**Applicant:** Mrs I Wainwright

**Description:** Replacement garage doors (Listed Building Consent) & Replacement of garage doors

**Site Address:** The Granary, 3 Fieldhead Manor, Elmhirst Lane, Dodworth, Barnsley, S75 4LD

FRONT / SIDE ELEVATION - AS PROPOSED

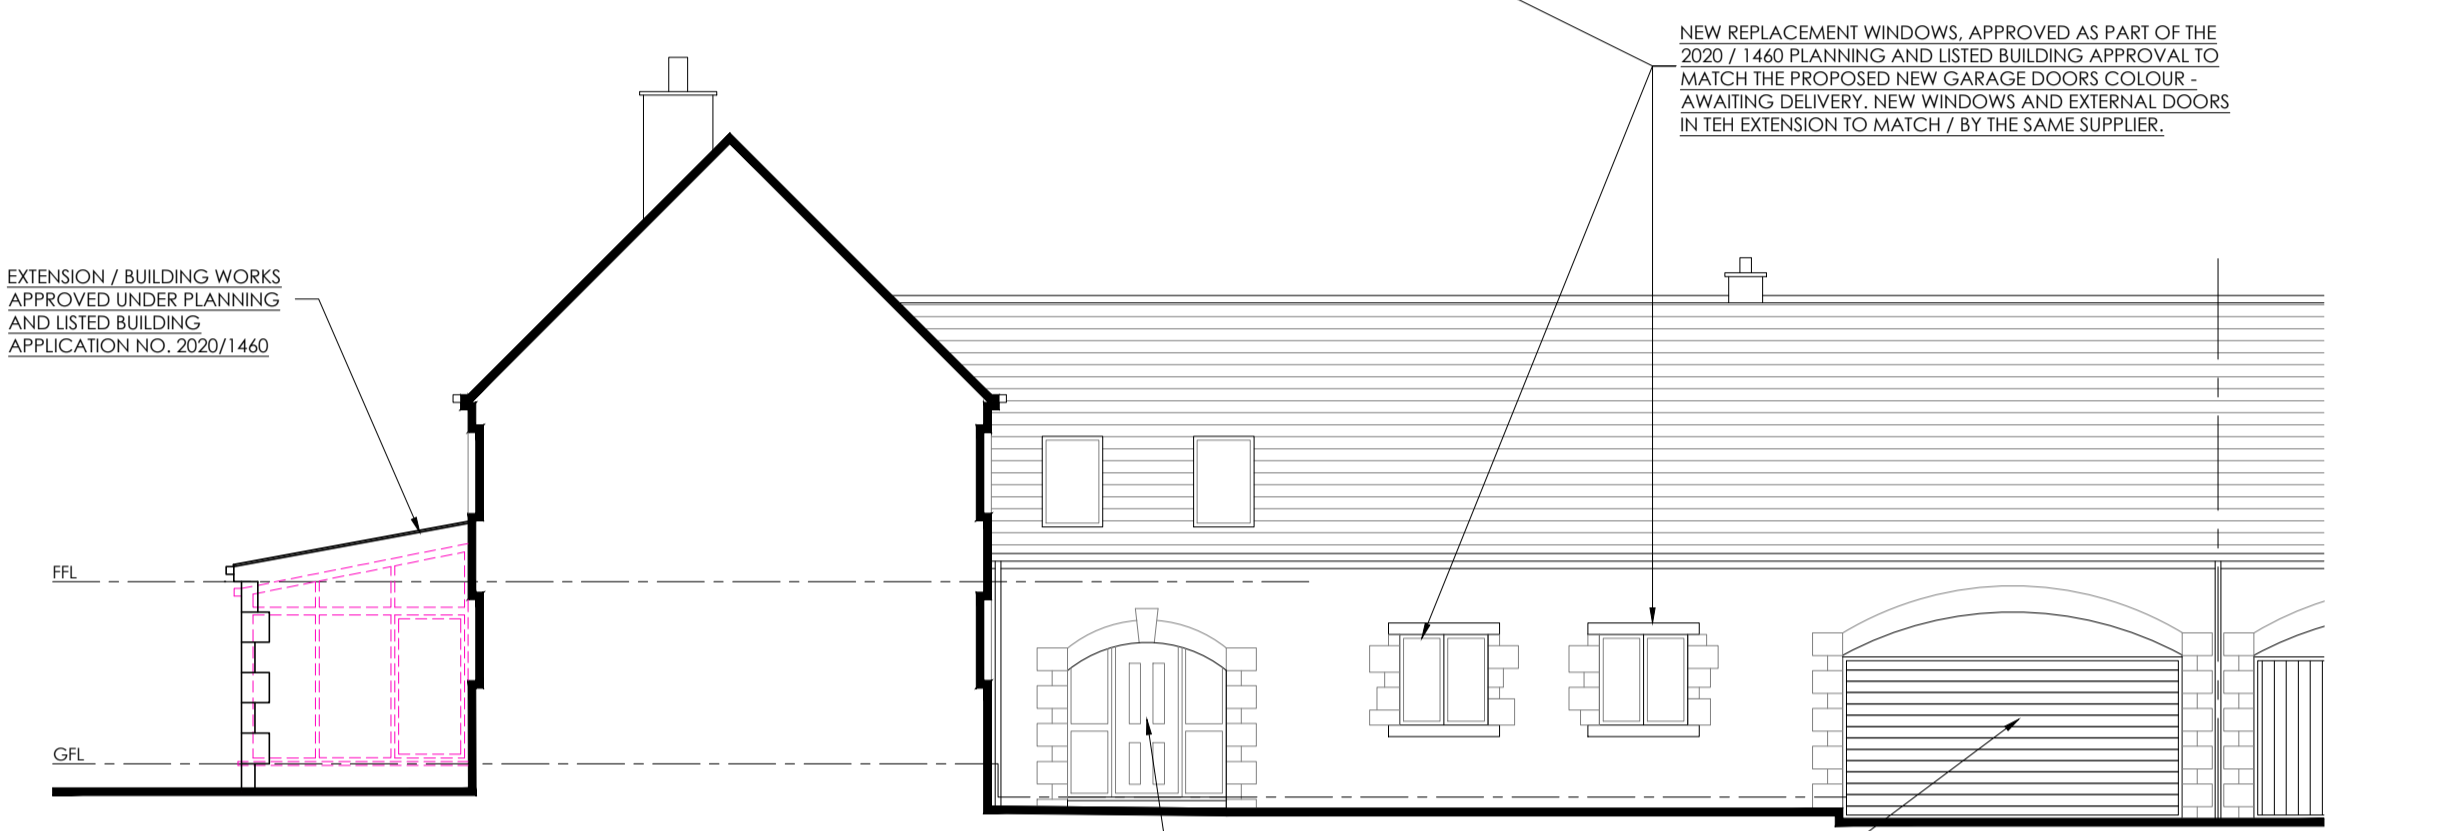
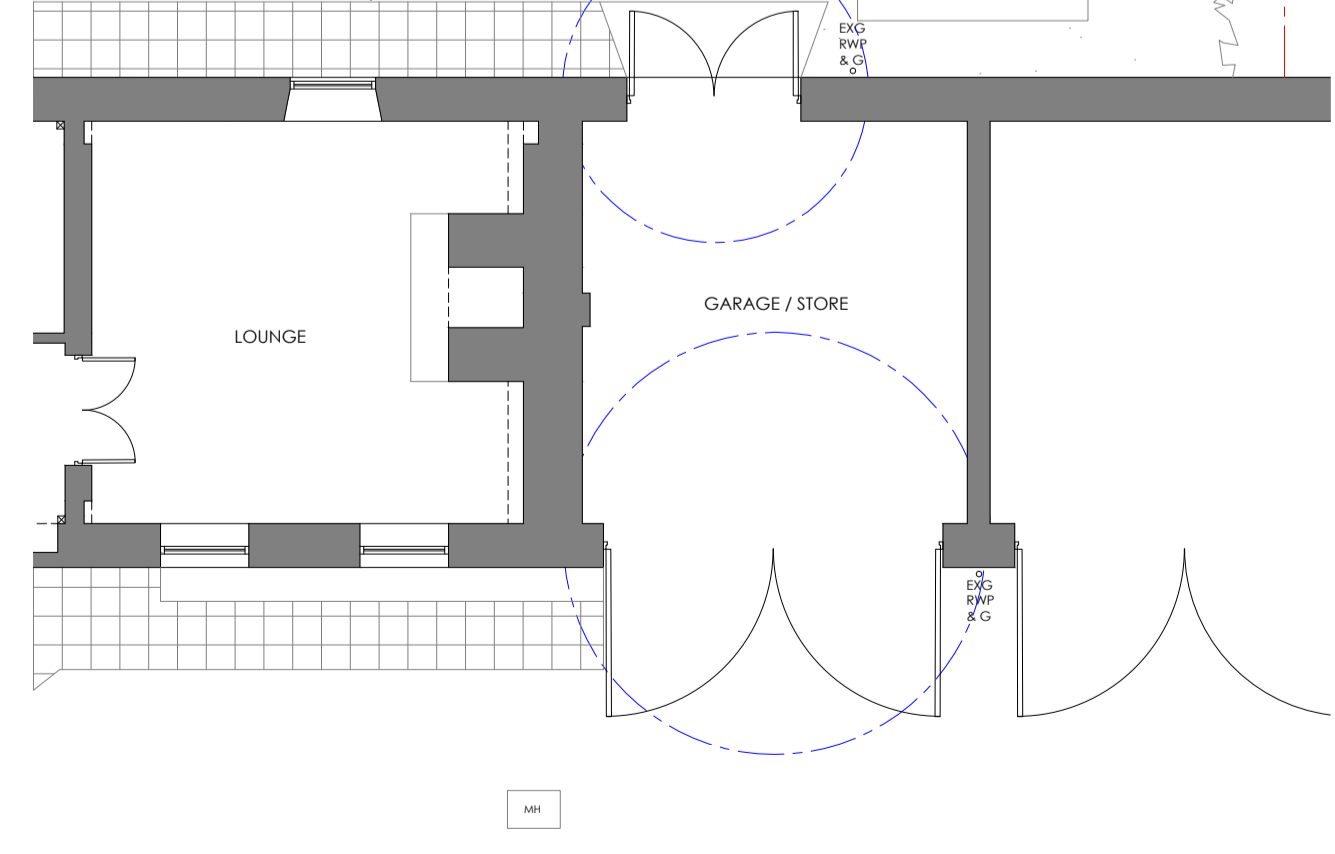
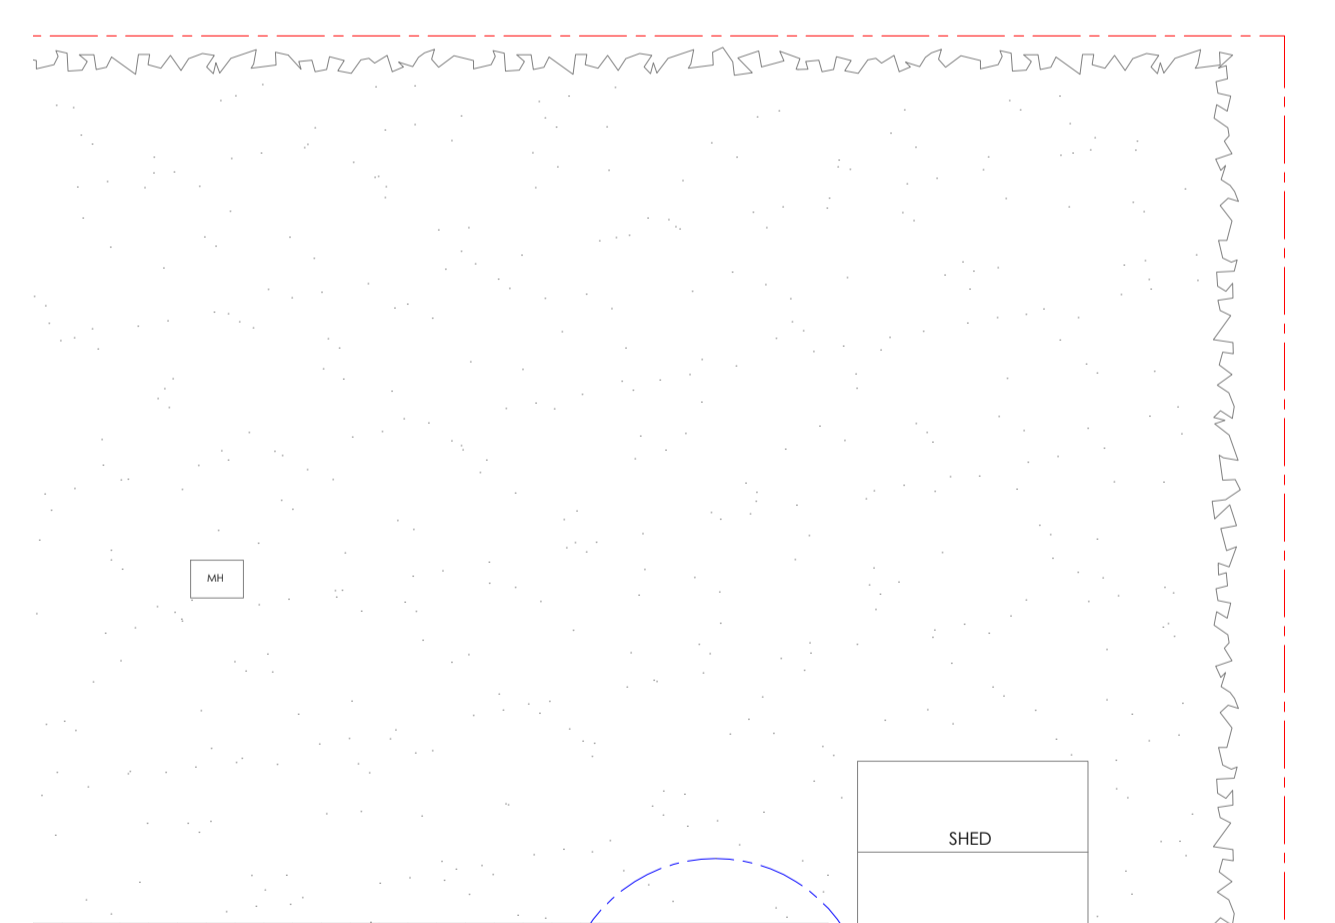
*Whilst it is conceivable this was believed not to need permission (the fence) I would suggest alterations (including garage doors) to the main fabric of the historic building are clearly matters needing listed building consent. Essentially, I think the design is less than ideal in terms of arrangement, materials, and decoration and in particular creates a visual mismatch between that of the application property garage and the one immediately adjacent.*

*strong visual disconnect with that of the immediately adjacent and attached garage opening and is strongly discordant from the vernacular.*

The design of the garage doors are modern in appearance and strongly at odds with the clearly historic appearance of the dwellinghouse/barn it is connected to. No consultation was undertaken with the LPA prior to installation of the garage doors and the applicant, given the recent planning decisions 2020/1455 and 1460, was aware of the loss of the permitted development rights on their property. By consequence the garage doors are considered contrary to LP Policies HE1 – The Historic Environment and HE3 – Development Affecting Historic Buildings as well as LP Policies D1 – High Quality Design and Placemaking and GB2 – Replacement, extension and alteration of existing buildings in the Green Belt which accord with the requirements of national policy as set out within the NPPF.

The design of the garage doors are modern in appearance and strongly at odds with the clearly historic appearance of the dwellinghouse/barn it is connected to. By consequence the garage doors are considered contrary to LP Policies HE1 – The Historic Environment and HE3 – Development Affecting Historic Buildings as well as LP Policies D1 – High Quality Design and Placemaking and GB2 – Replacement, extension and alteration of existing buildings in the Green Belt which accord with the requirements of national policy as set out within the NPPF. As such, the works are refused planning permission and listed building consent and enforcement action shall be taken by the Local Planning Authority which will seek to replace the garage doors with a more sympathetic design.
